Reference No:	2024/62/93068/E
Site Address:	1, Chadwick Crescent, Dewsbury, WF13 2JF
Description:	Erection of single storey front extension, single storey side extension and single and two storey rear extension
Recommending Officer:	Jennifer Booth

DECISION – CONDITIONAL FULL PERMISSION

OFFICER REPORT

DRAWING REF:
24312-D03-B

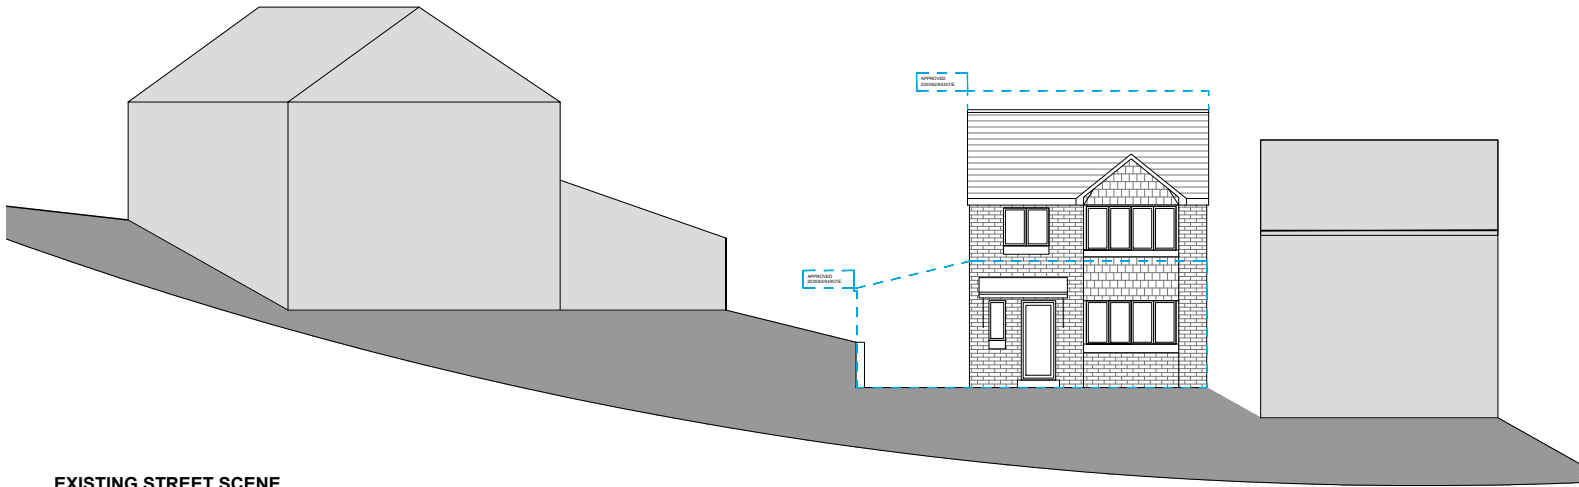
Although the individual elements of the scheme could be supported, the initially submitted plans would have cumulatively formed additional which would not be subservient to the property and would have resulted in changes to the character of the host property which would not be considered to be acceptable in terms of visual amenity. However, amended plans have been provided which removed the first floor element of the side extension which is considered to sufficiently reduce the level of development to a subservient level.

The proposals as initially submitted failed to comply with the SPD and would have resulted in a significant overbearing and oppressive impact on the adjacent 15 Infirmary Road. Amended plans have been sought and received to remove the first floor side elevation.

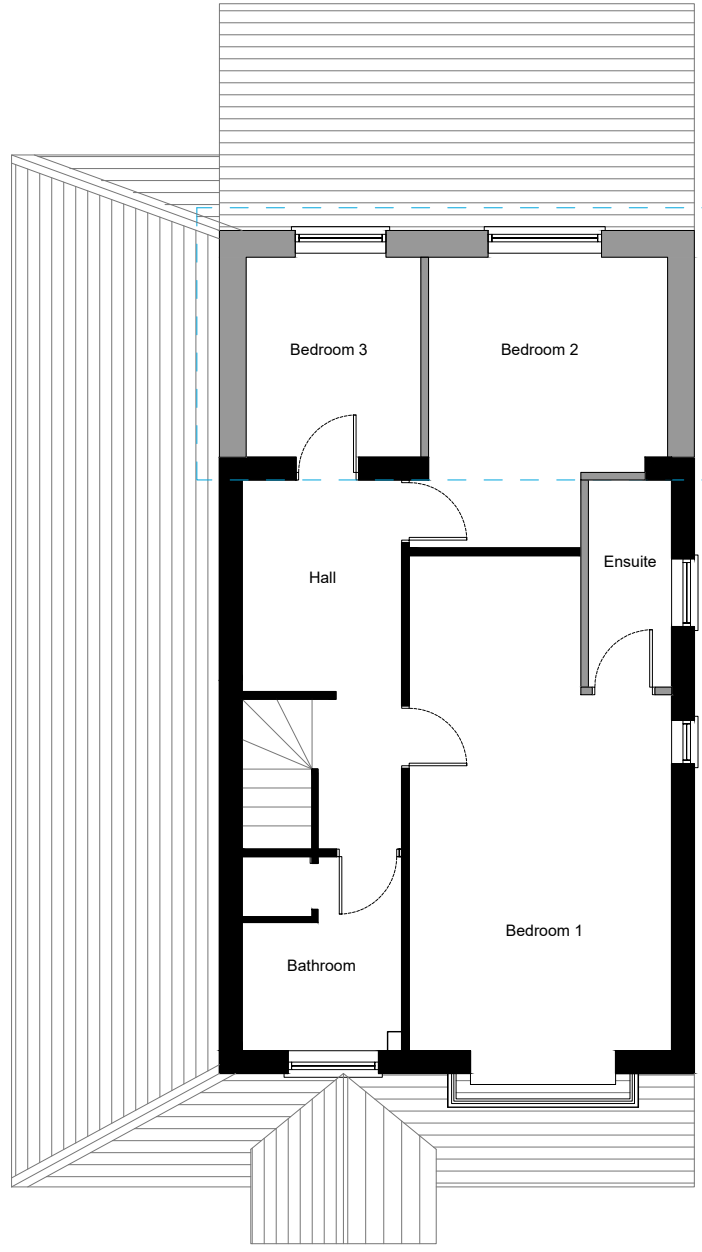
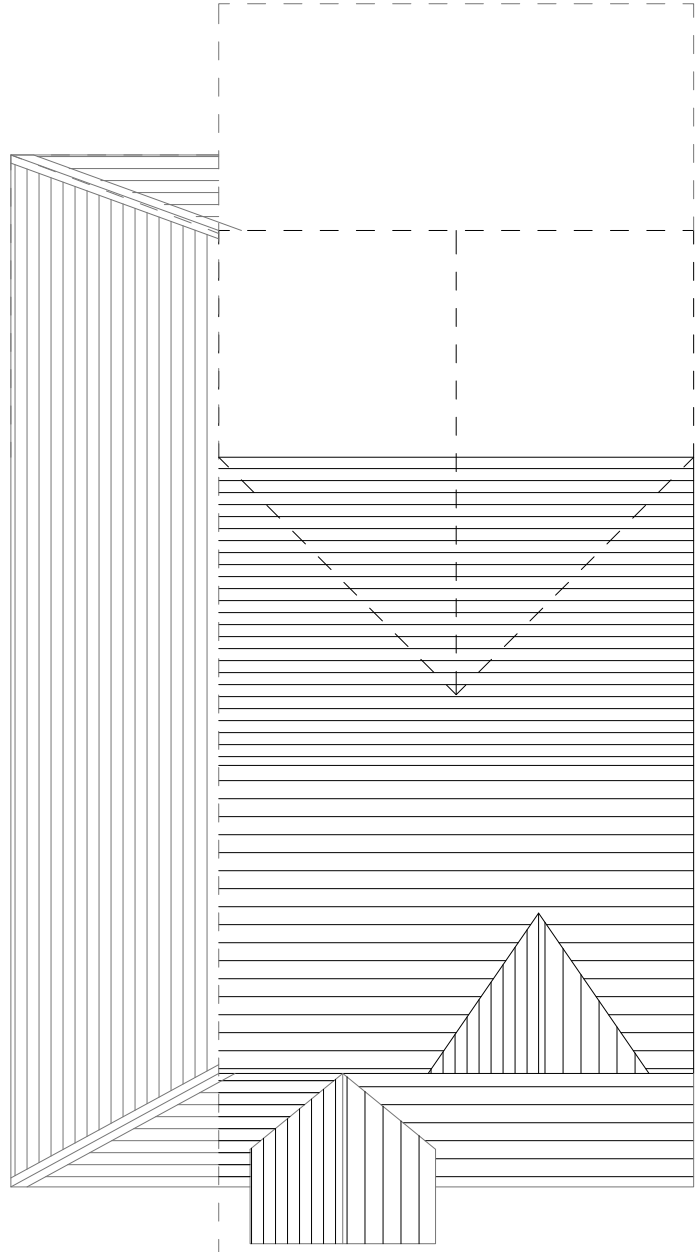
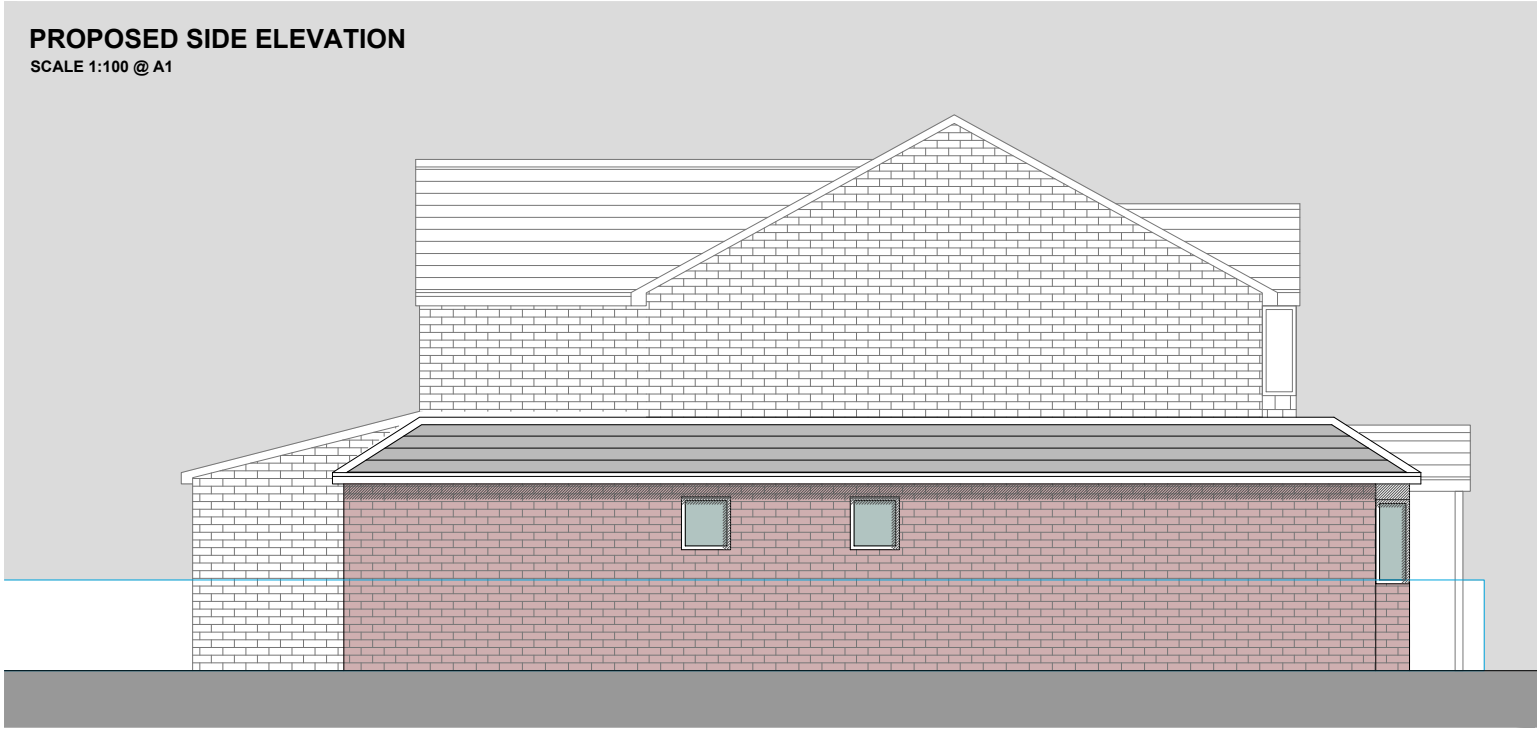
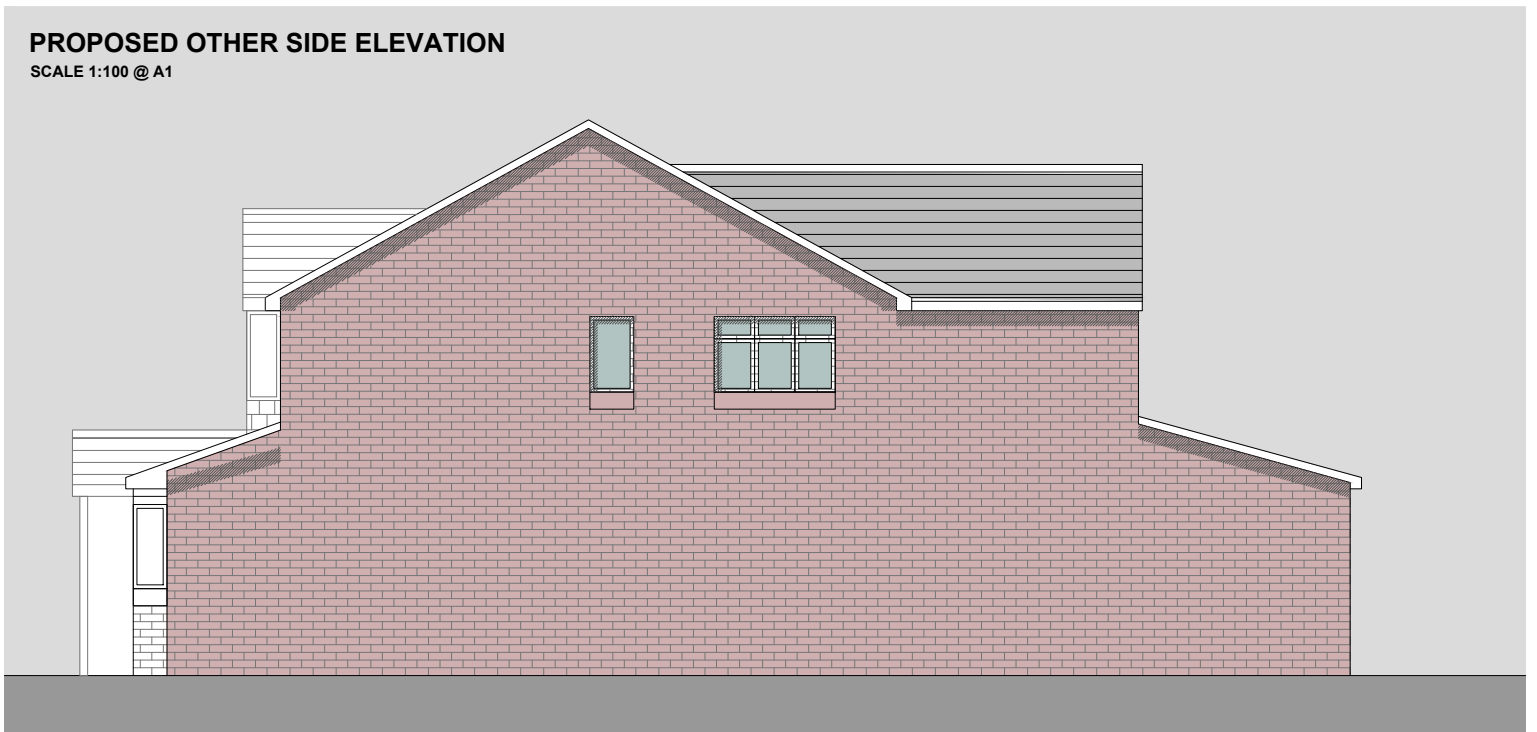
Kirklees Development Management Charter together with the National Planning Policy Framework and the DMPO 2015 encourages negotiation/engagement between Local Planning Authorities and agents/applicants, this is only within the scope of the application under consideration. The proposals as initially submitted failed to comply with the SPD and would have resulted in a significant overbearing and oppressive impact on the adjacent 15 Infirmary Road. Amended plans have been sought and received to remove the first floor side elevation.
